City of Albuquerque Stormwater Construction Site Inspection Report

Project Name and Location	Campo del Norte Alameda 4 Signal		
Site Contact Name & Agency	Patricia Holmes Kevin Patton	ESC File No. NPDES ID No.	C1BE102 NMP100140
Date of Inspection	11-13-18	Start/End Time	10:35/11:20
COA Inspector Name	Curtis Cherne, Stormwater Quality		
Describe Present Phase of Construction	grading

CAMPO DEL NORTE
EROSION CONTROL PLAN

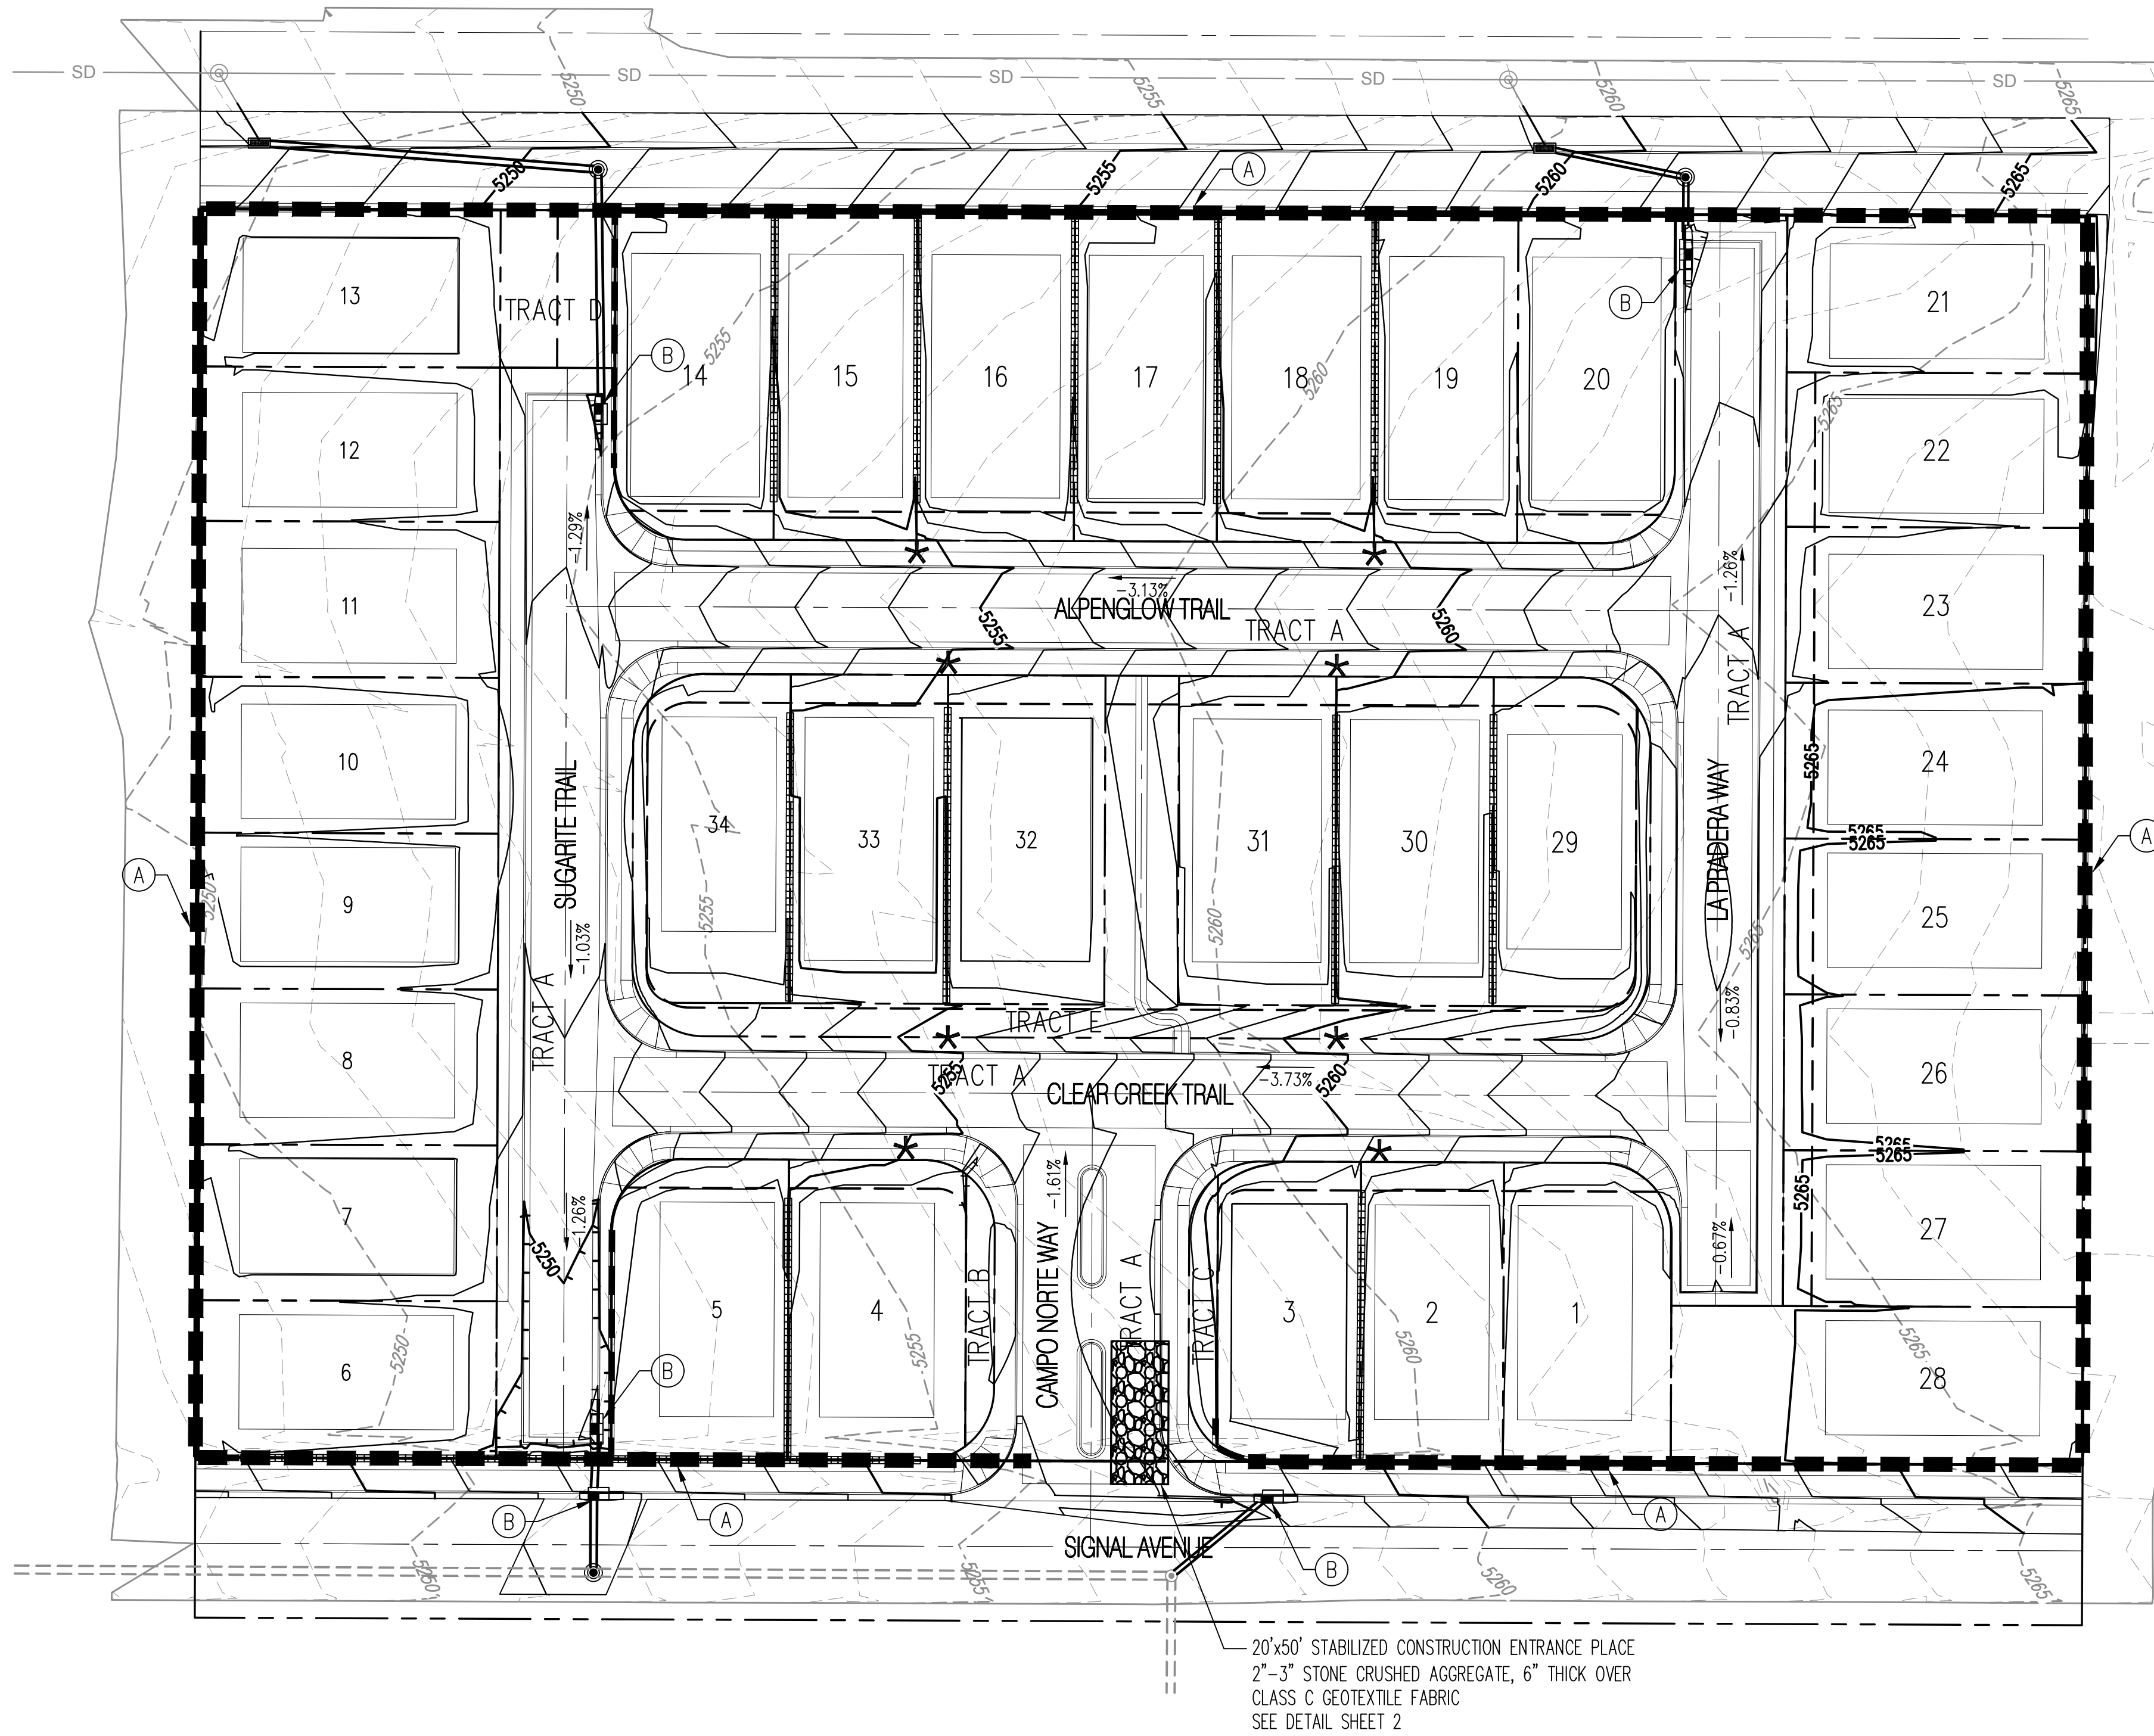
CGP	BMP / Activity	Maintenance Required? (1)	Corrective Action Required? (2)	Location and Notes
1.5	Post a Notice			
2.2.1	Provide and maintain Natural buffer when Waters of the US < 50 ft			
2.2.3	Sediment control along any perimeter		✓	South edge east of pad #2 Sediment BMP
2.2.3	Sediment control along any perimeter		✓	South edge west end - no BMP
2.2.3	Sediment control along any perimeter	✓		hole under wall west edge - 15' north
2.2.3	Sediment control along any perimeter	✓		west edge - new north end - silt fence full
2.2.3	Sediment control along any perimeter			
2.2.3	Sediment control along any perimeter			
2.2.3	Sediment control along any perimeter			
2.2.4	Minimize sediment track-out			
2.2.5	Manage stockpiles

2.2.6	Minimize Dust			
2.2.10	Protect Storm Drain Inlets		✓	calhart driveway SW corner
2.2.10	Protect Storm Drain Inlets			
2.2.11	Minimize erosion of conveyance channels
